DRB CASE NO/PROJECT NO: 1006770

Sketch Plat/Plan

PROJECT # 1006770

RE: Tracts 145A and 145B, MRGCD Map # 38

SP-1

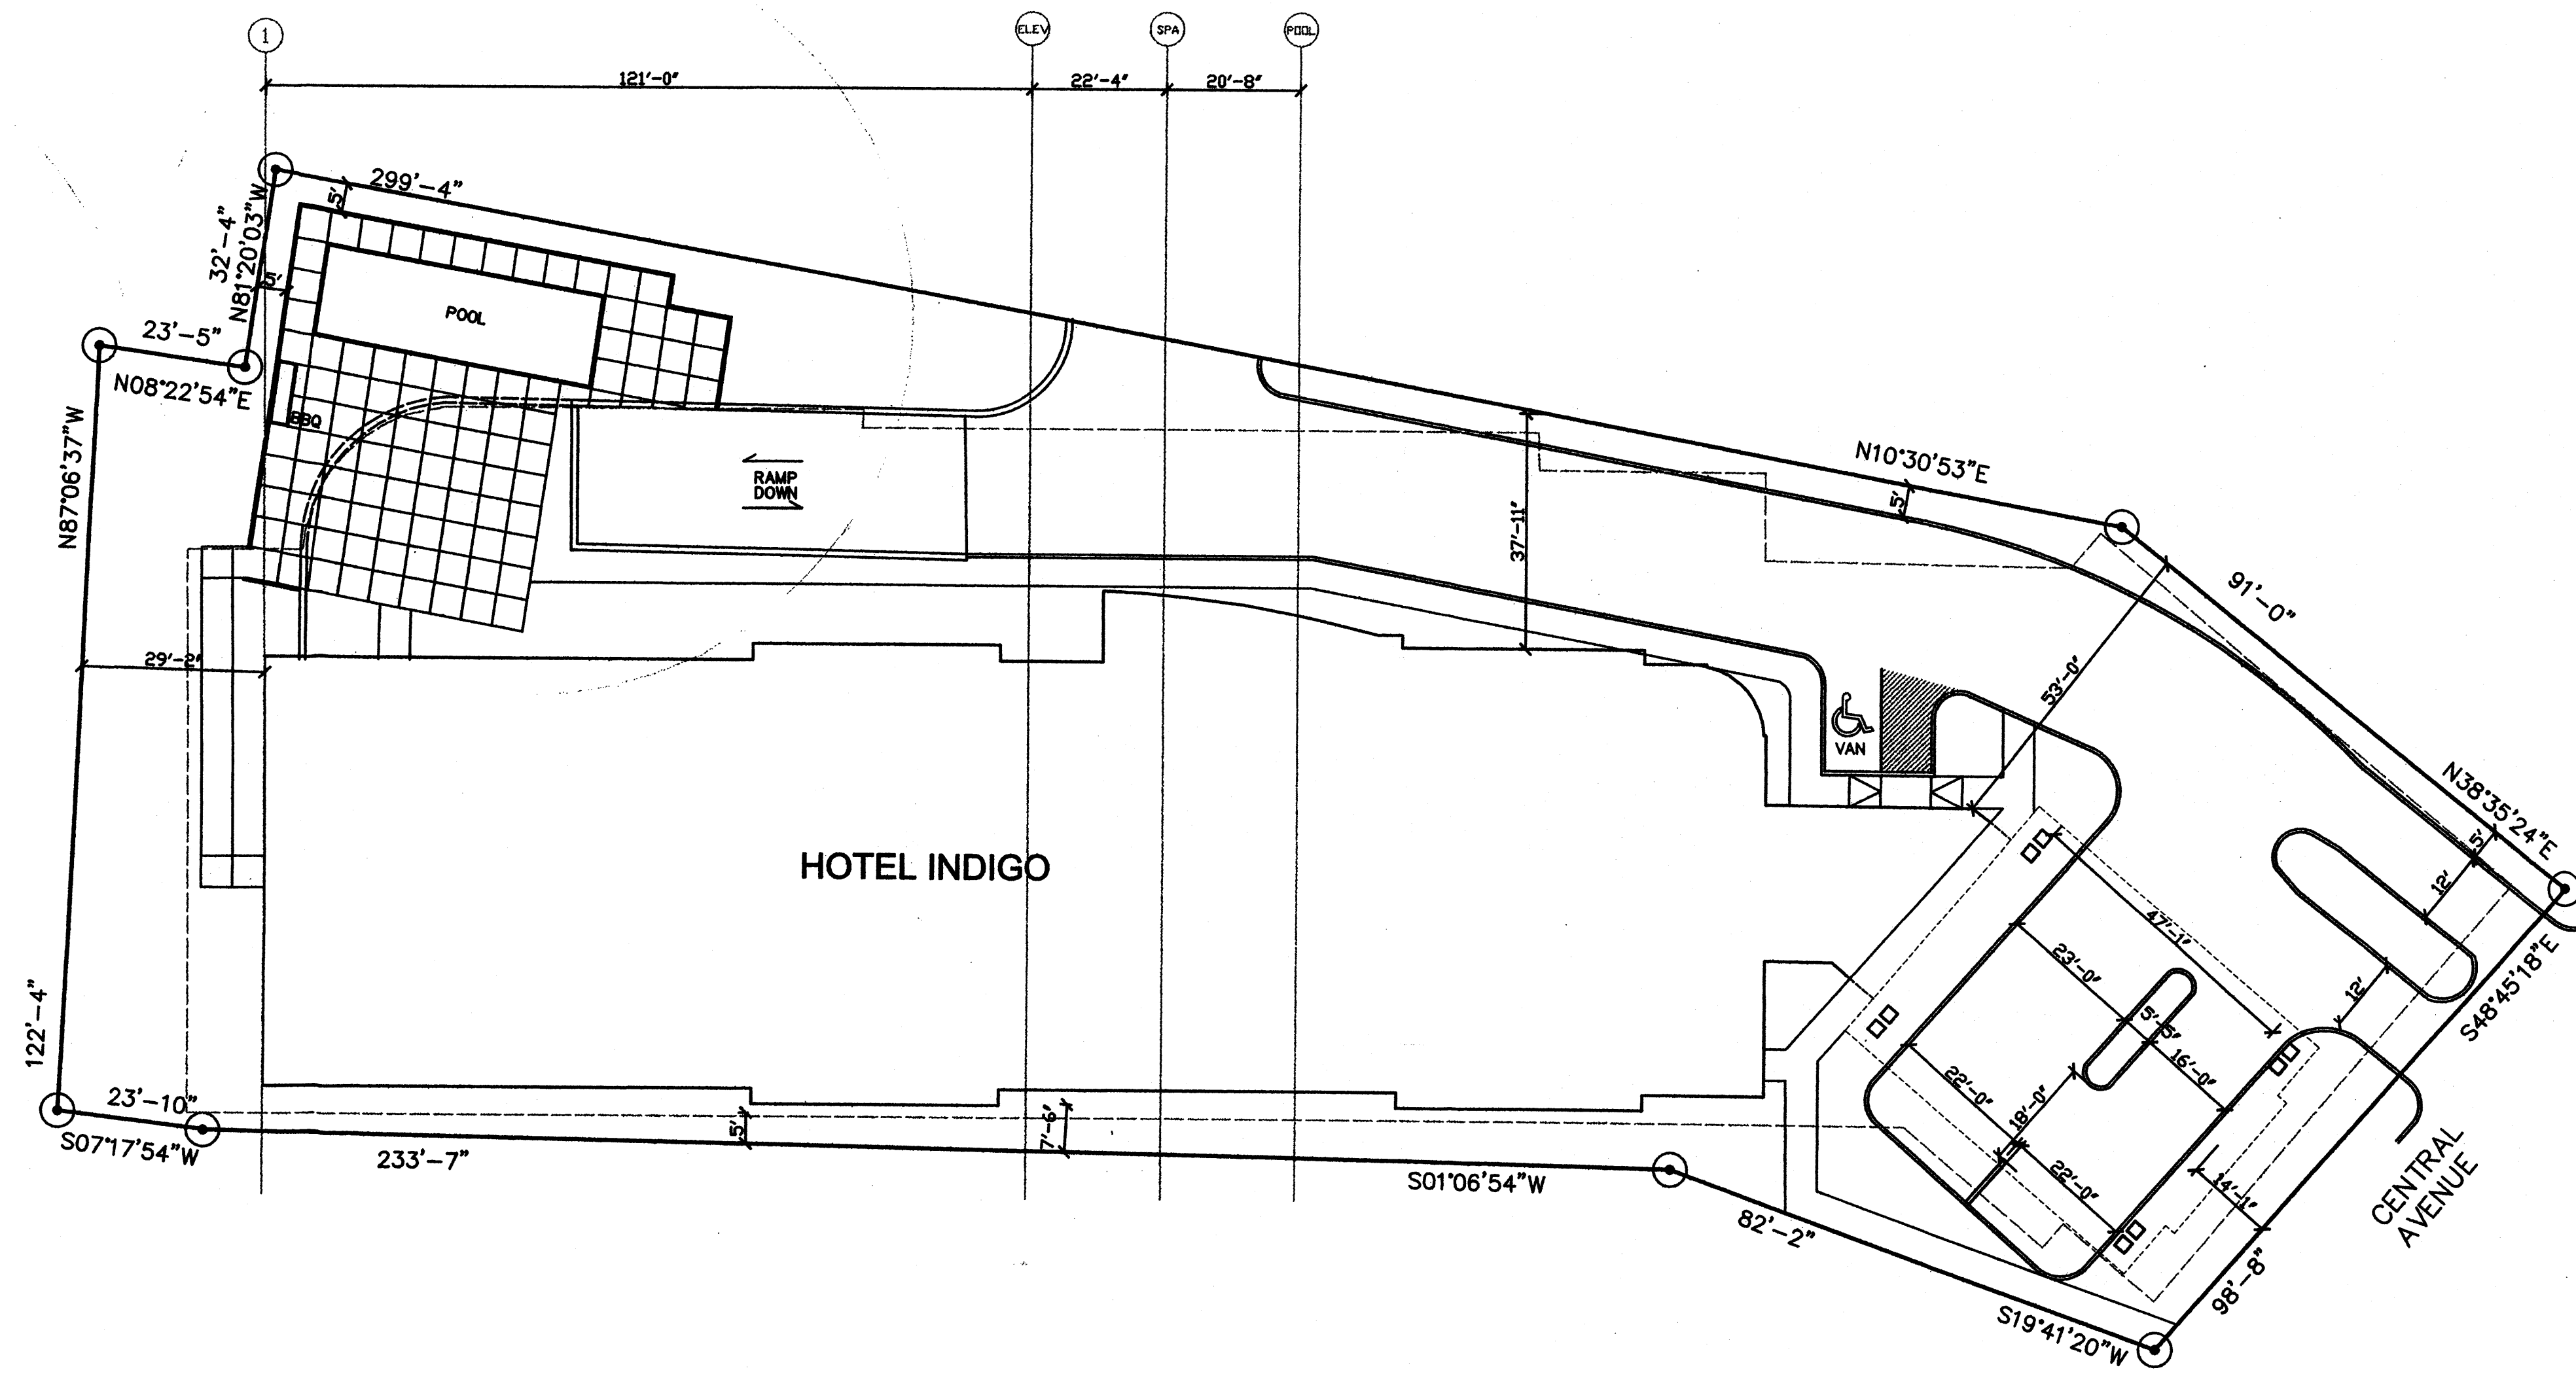
Provide an exhibit showing the location of sidewalk and defining the distance from face of curb to the property line. Right of way dedication may be required.

Planning Department has no adverse comment on proposed lot line elimination by platting; however, consideration might be given to restricting secondary access in order to avoid 'cut thru' traffic.
